From: Martyn White
Sent: 19 July 2019 14:42
To: Planning.Responses <Planning.Responses@arun.gov.uk>
Cc: Anita Gardner <Anita.Gardner@arun.gov.uk>
Subject: LU/126/19/PL

LU/126/19/PL

The application proposes the demolition of the existing car garage/workshop and the erection of two blocks of apartments, which collectively provide 9 residential units. One of the units will front on to River Road, whilst the other will front on to Terminus Place.

Proposed Drawings:
Terminus Place
Roof Plan

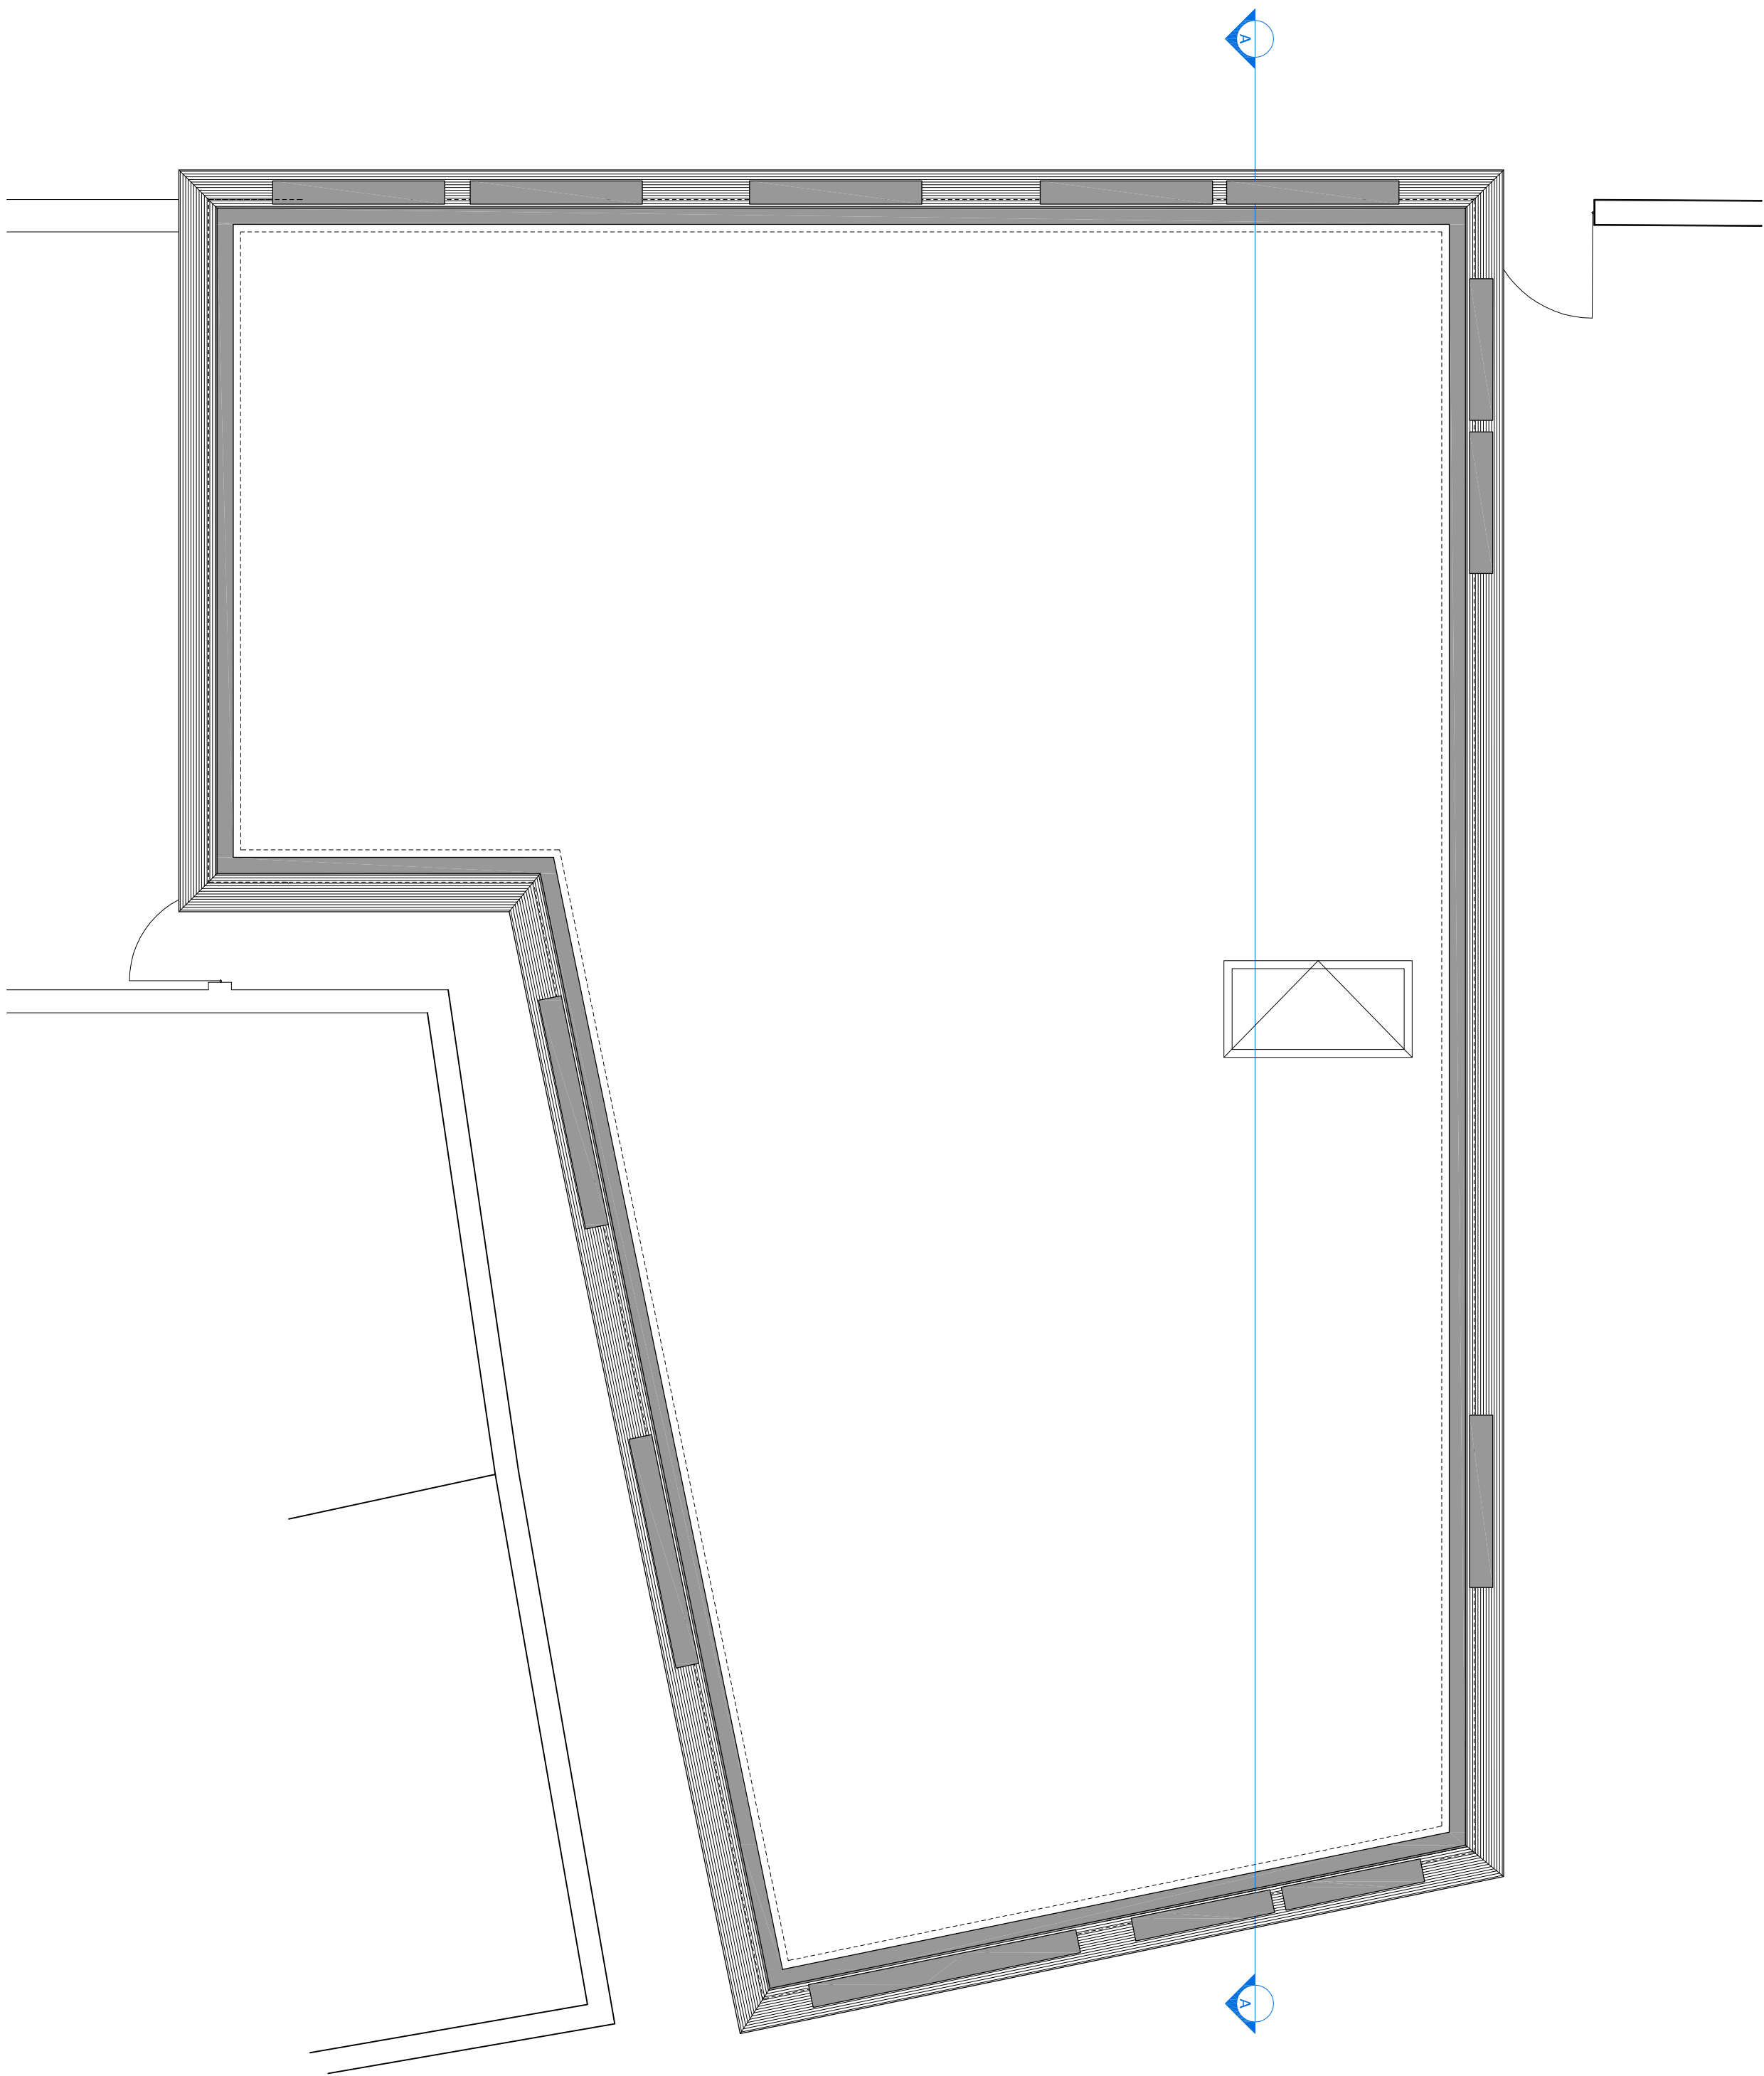
As with the River Road apartment block, it is noted that apart from the existing apartment block, the properties are constructed with pitched roofs, whereas the proposed building will have a mansard roof. This is out of character, and it is not clear what the justification for this is. This issue is especially important on the road facing elevation.

PROPOSED DRAWINGS:
Terminus Place
Proposed & Existing Street Scenes

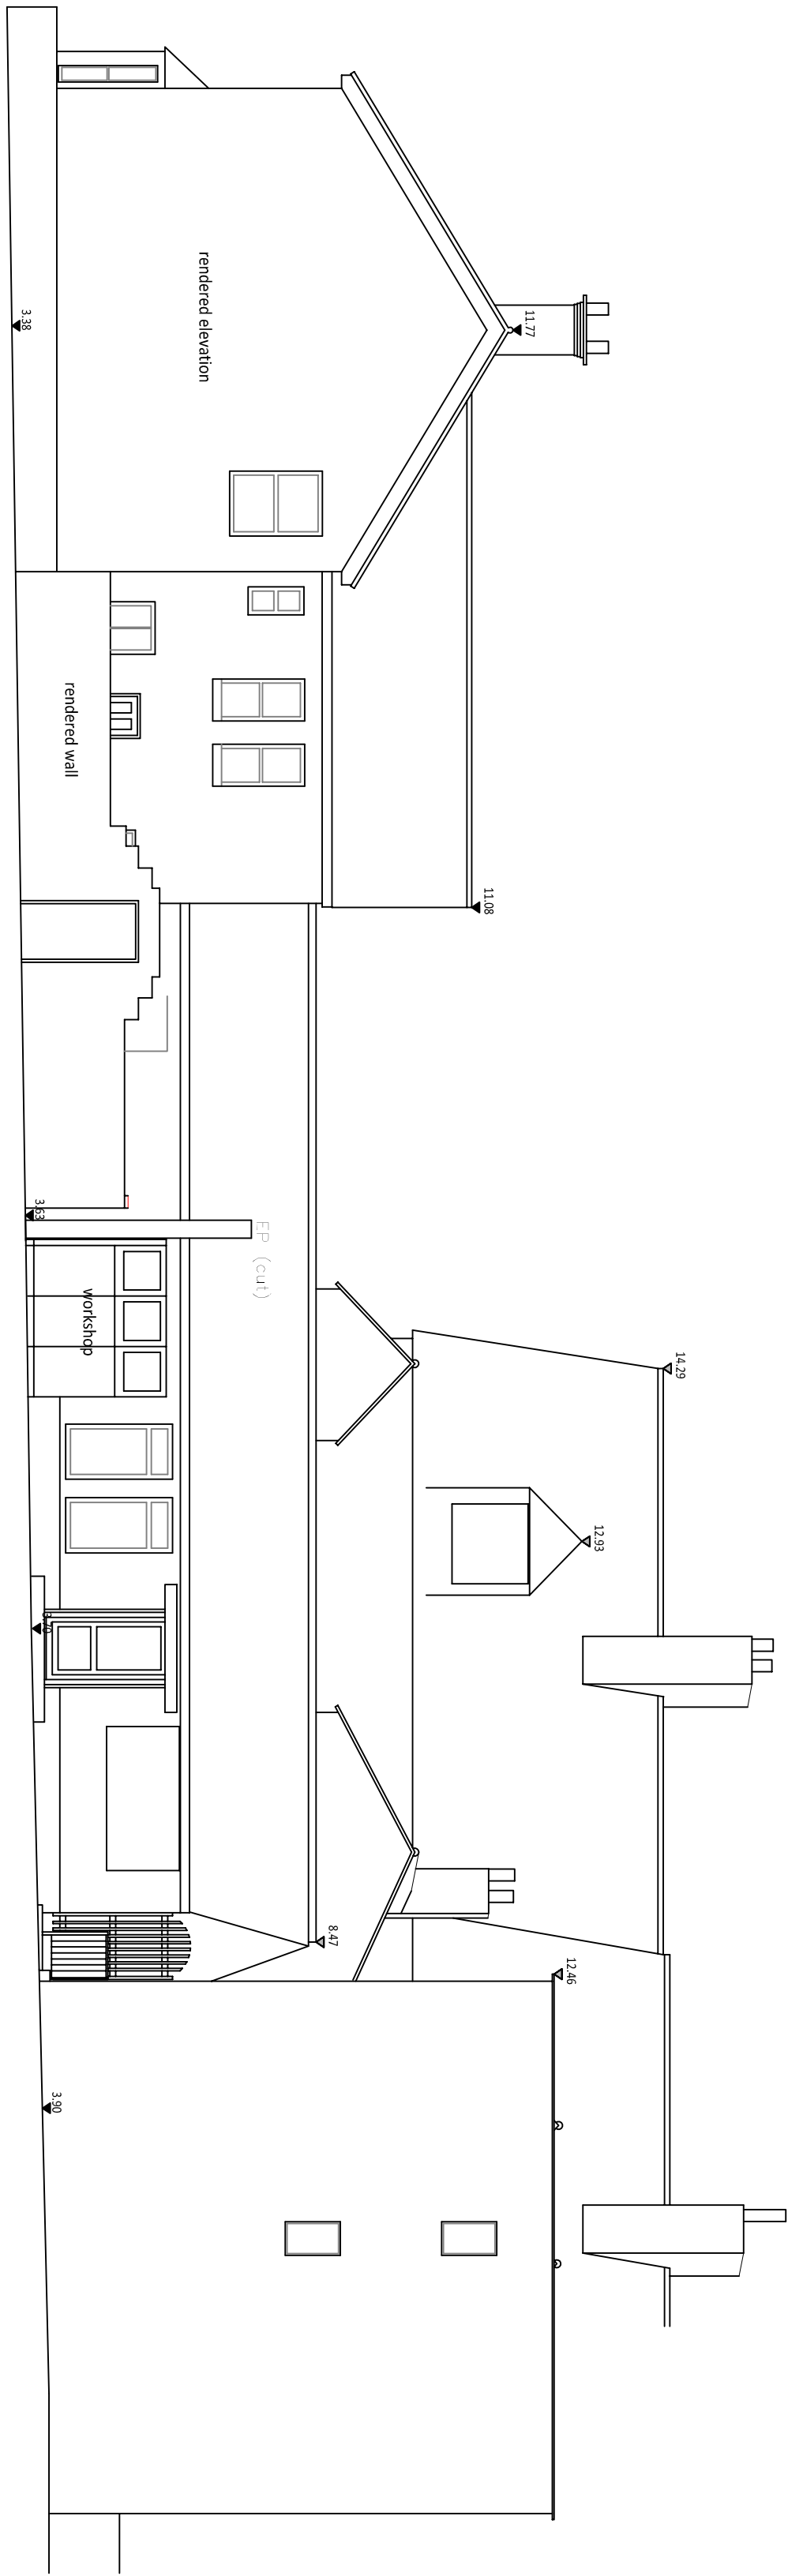
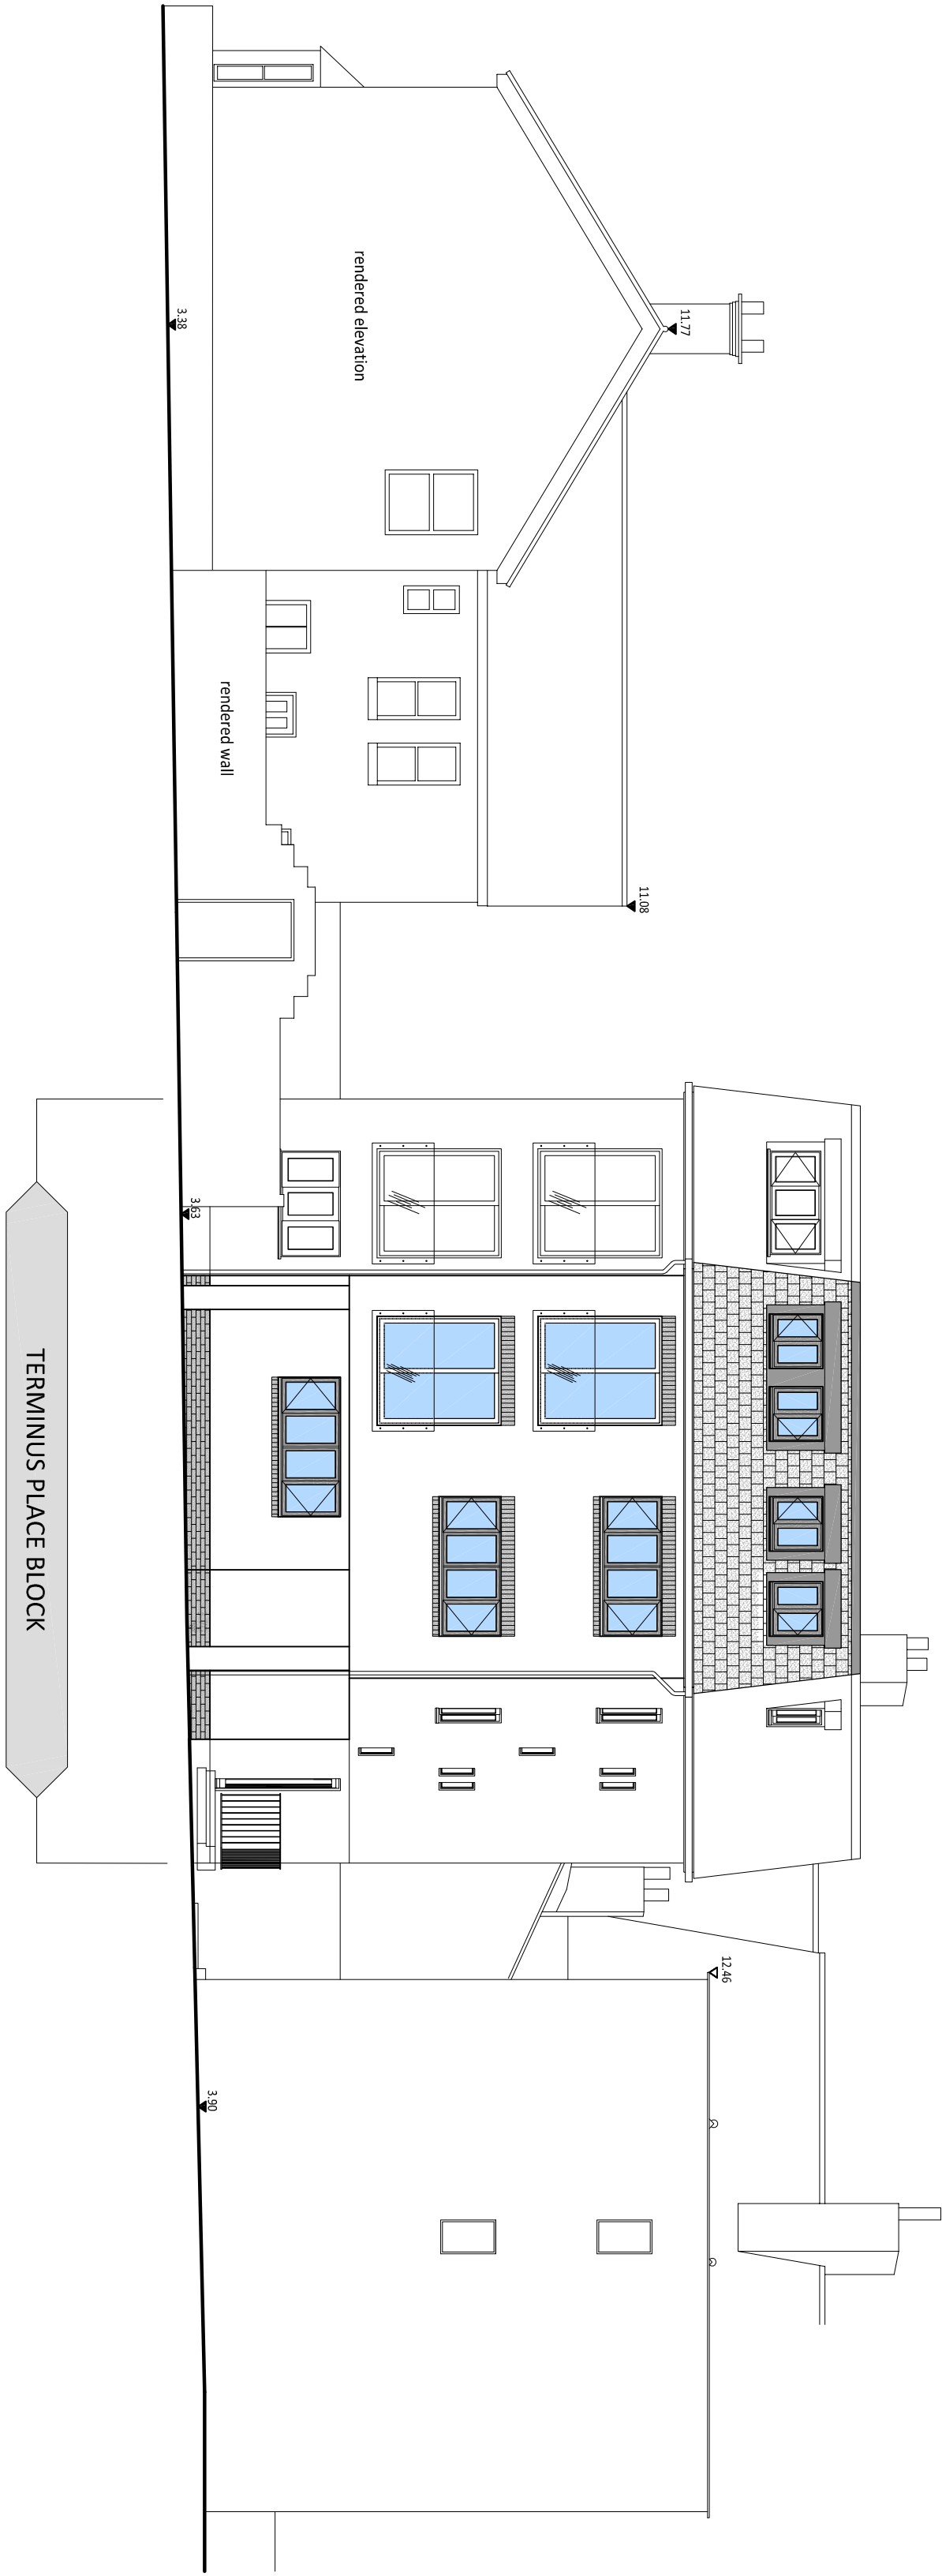
Terminus Place Apartments: This apartment block is much larger than the first one. Whilst there is an apartment block to the north of this, it appears to be only three storeys, as opposed to the proposed 4.

Both the existing, and the proposed block of apartments are in conflict with the general character of Terminus Place (and Purbeck Place) where the traditional properties within the conservation area are two storey, terraced houses. This character is also evident on the section of River Road closest to the application site.

Further, the presence of the Undercroft, and varied fenestration pattern, means that the building does not have a positive impact upon the street-scene.
